Development Control
Ribbles Valley Borough Council

App no: 23.0953

Address: Old Row Whalley Road Barrow

**Proposal: Discharge of condition no. 11 (detailed site access arrangements)
from planning permission 3/2023/0153**

Title
Proposed Highway Works GA Plan

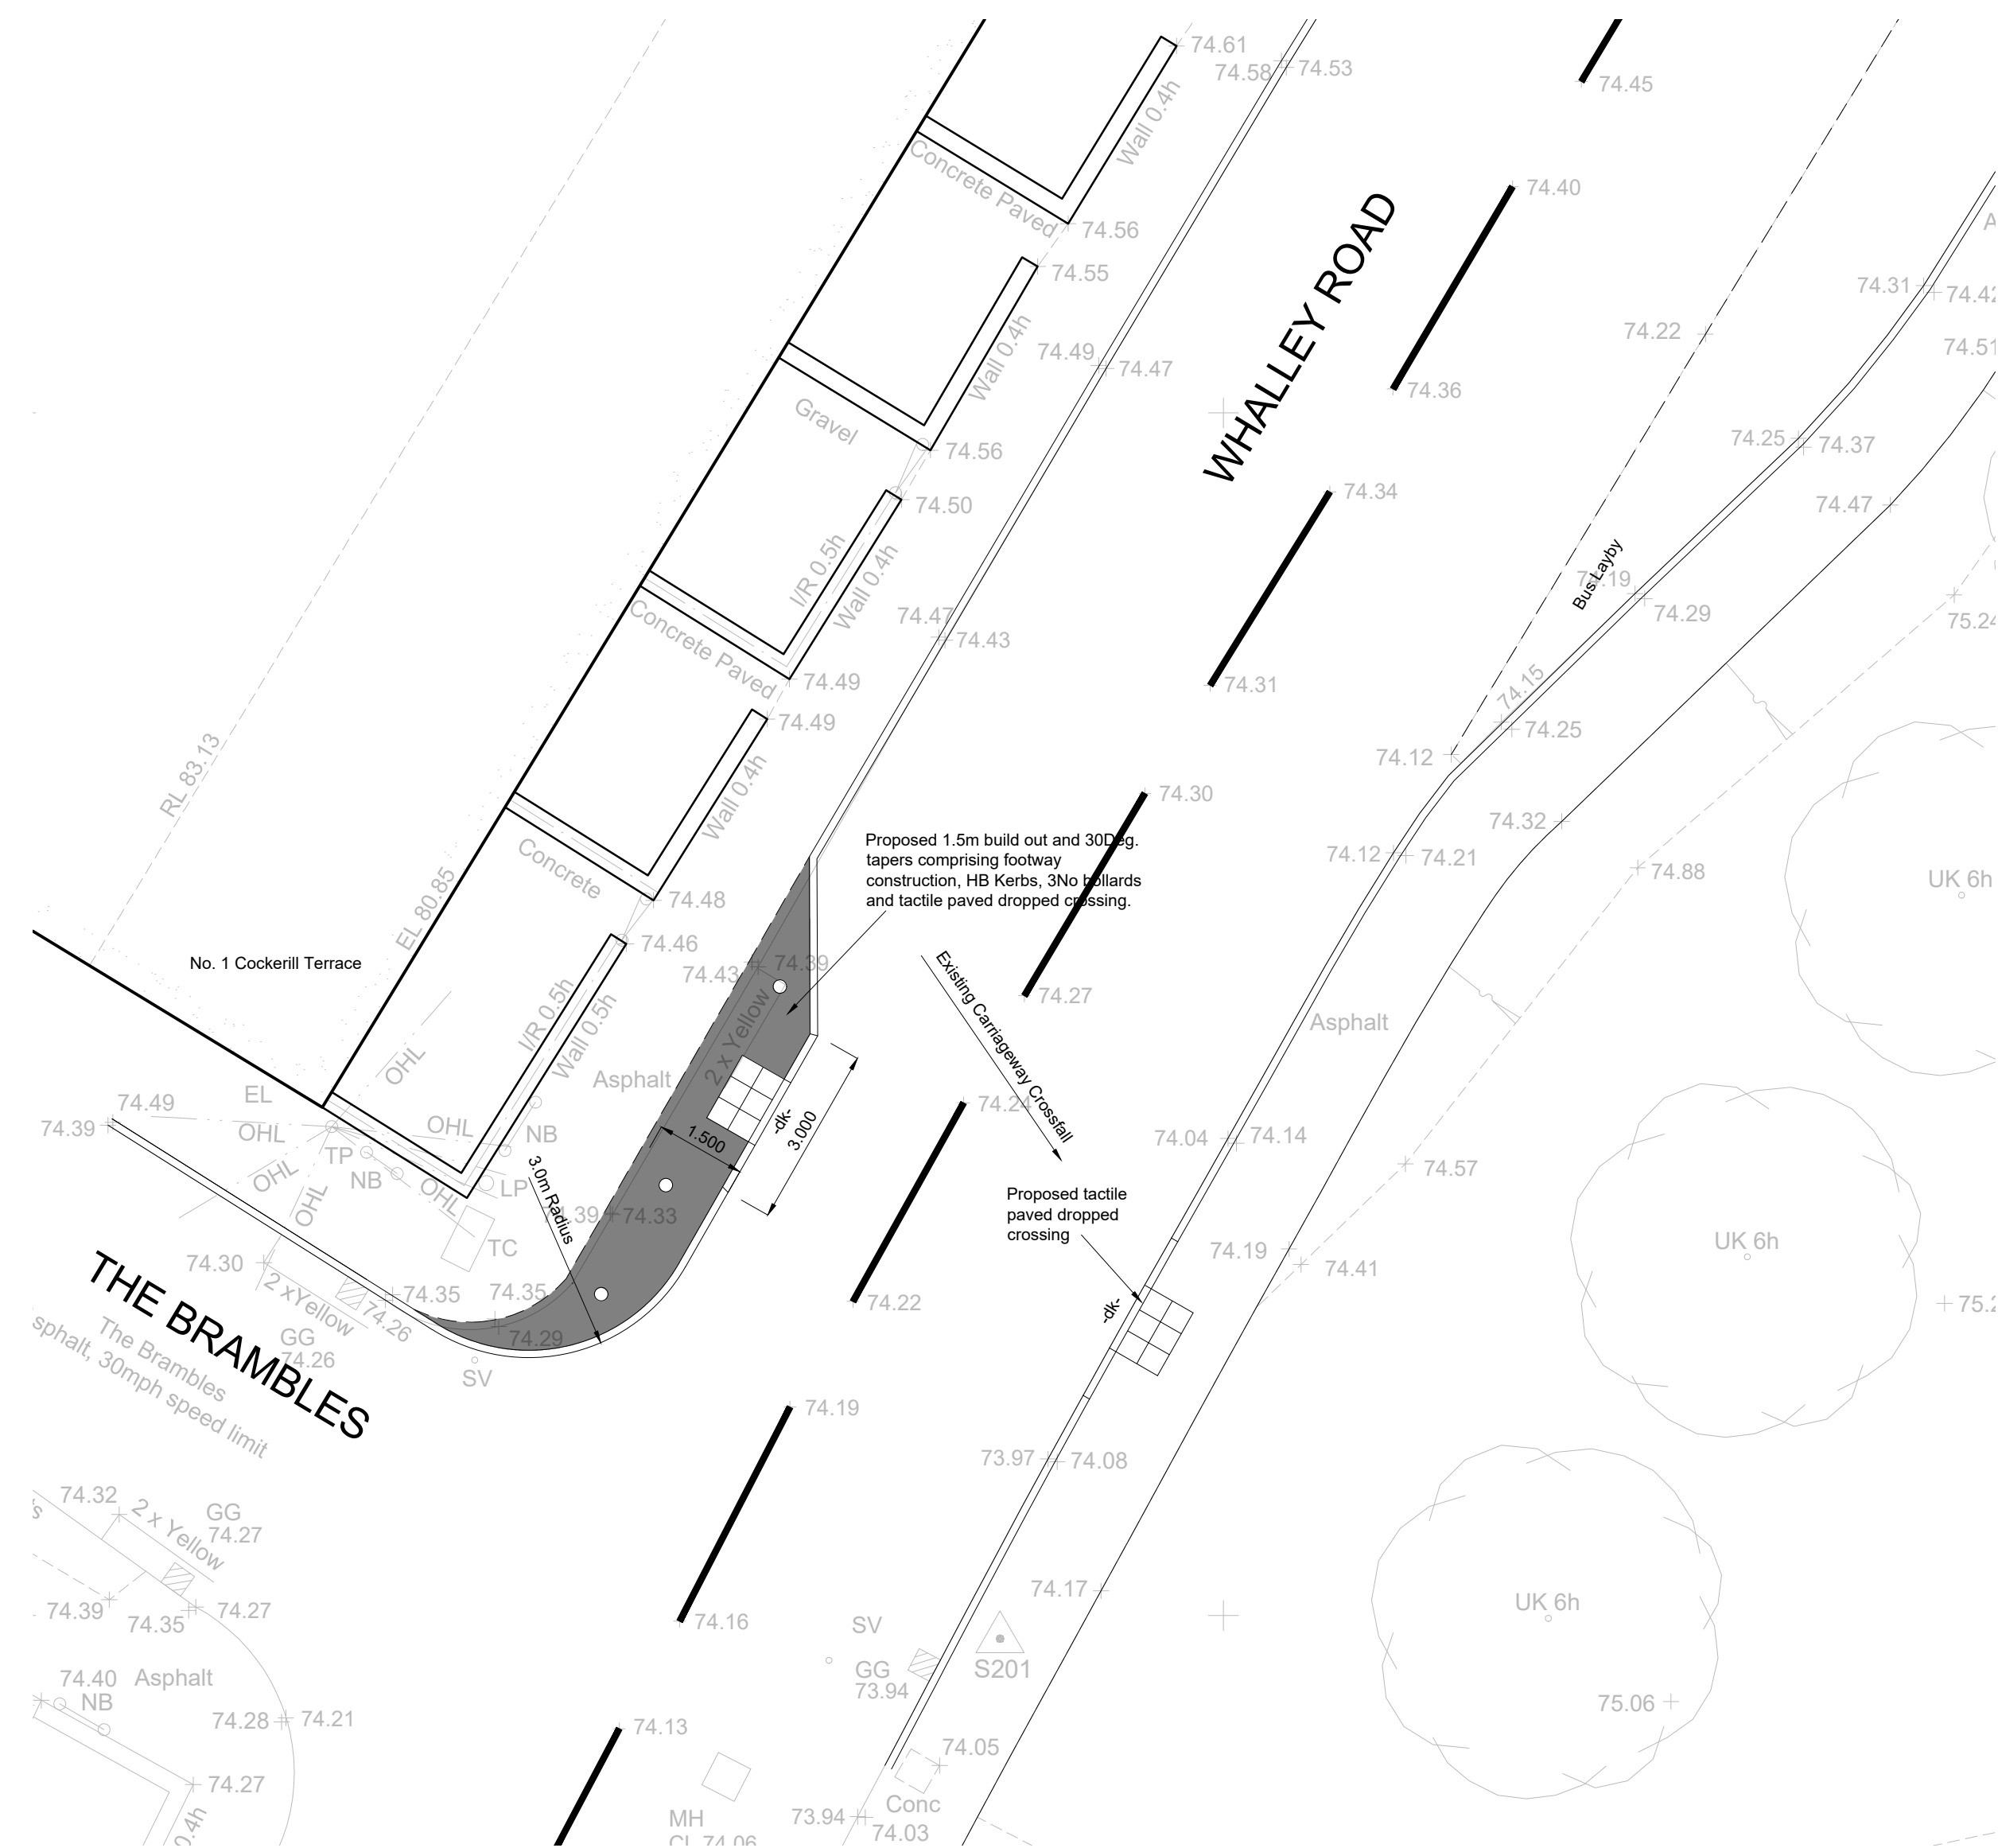
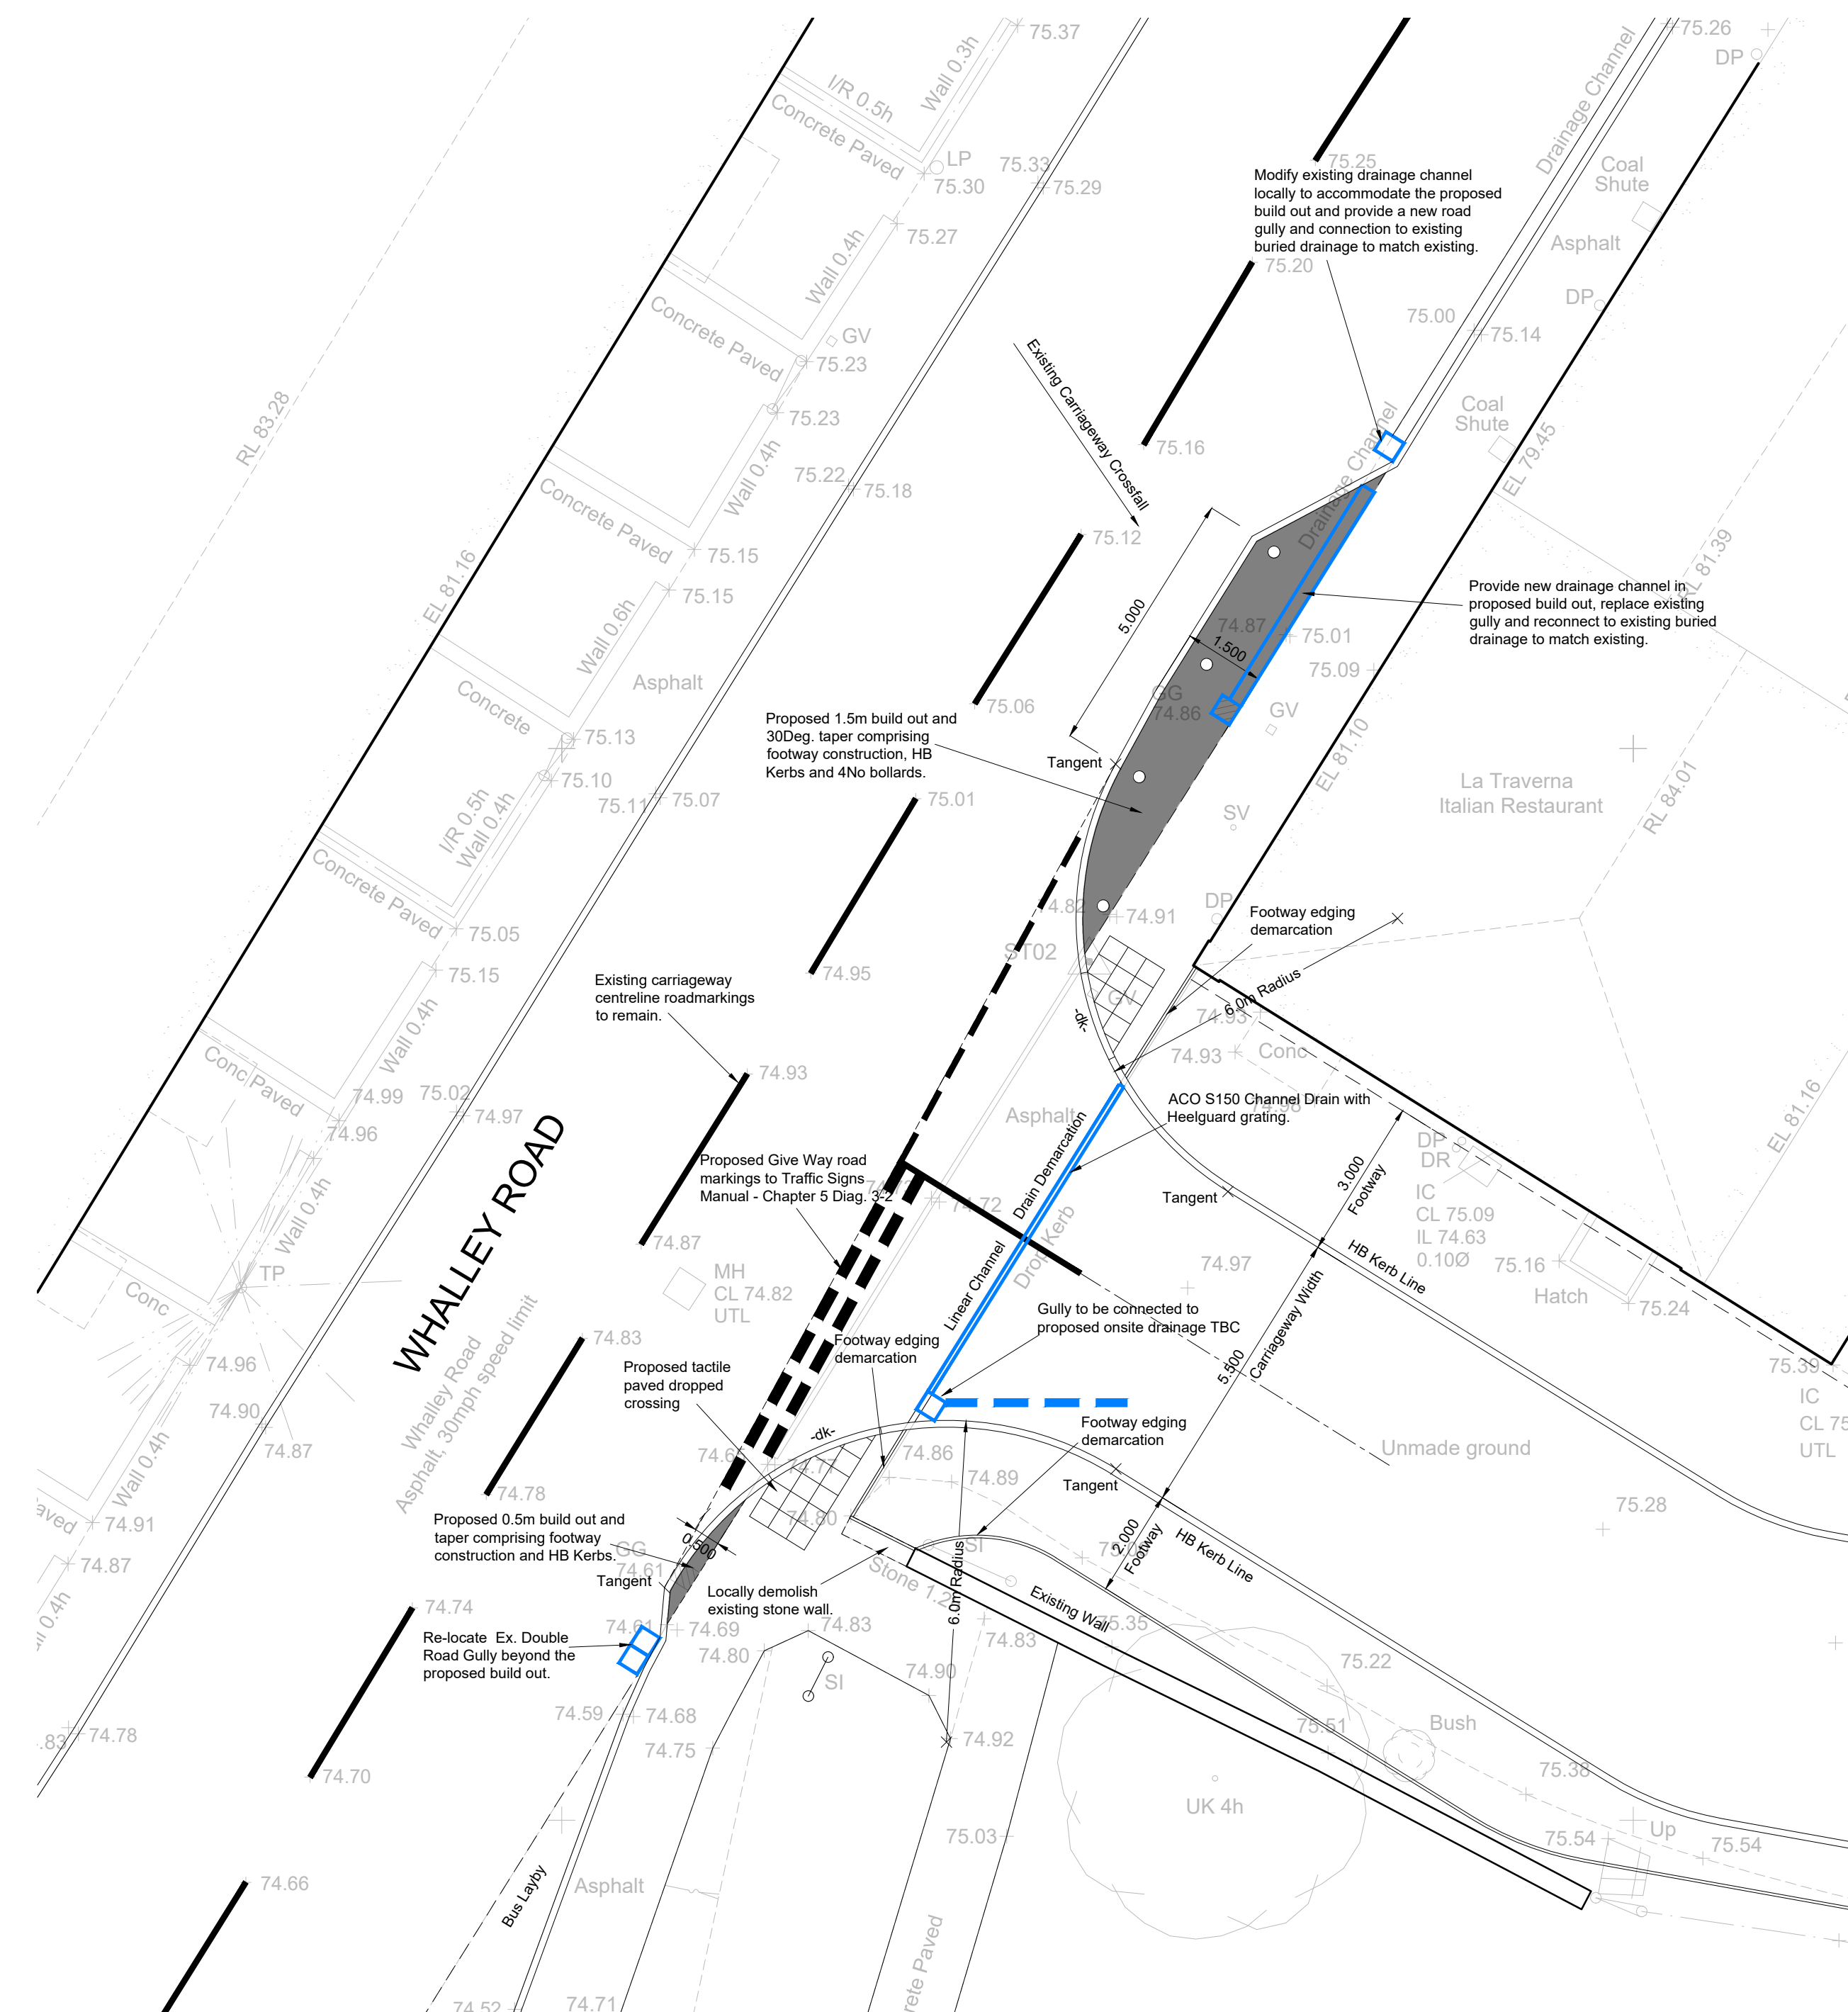
The submitted drawing has insufficient detail to enable the discharge of this condition. The site access layout does not reflect the approved layout with the footway on the southern side being significantly narrower in width than the northern side.
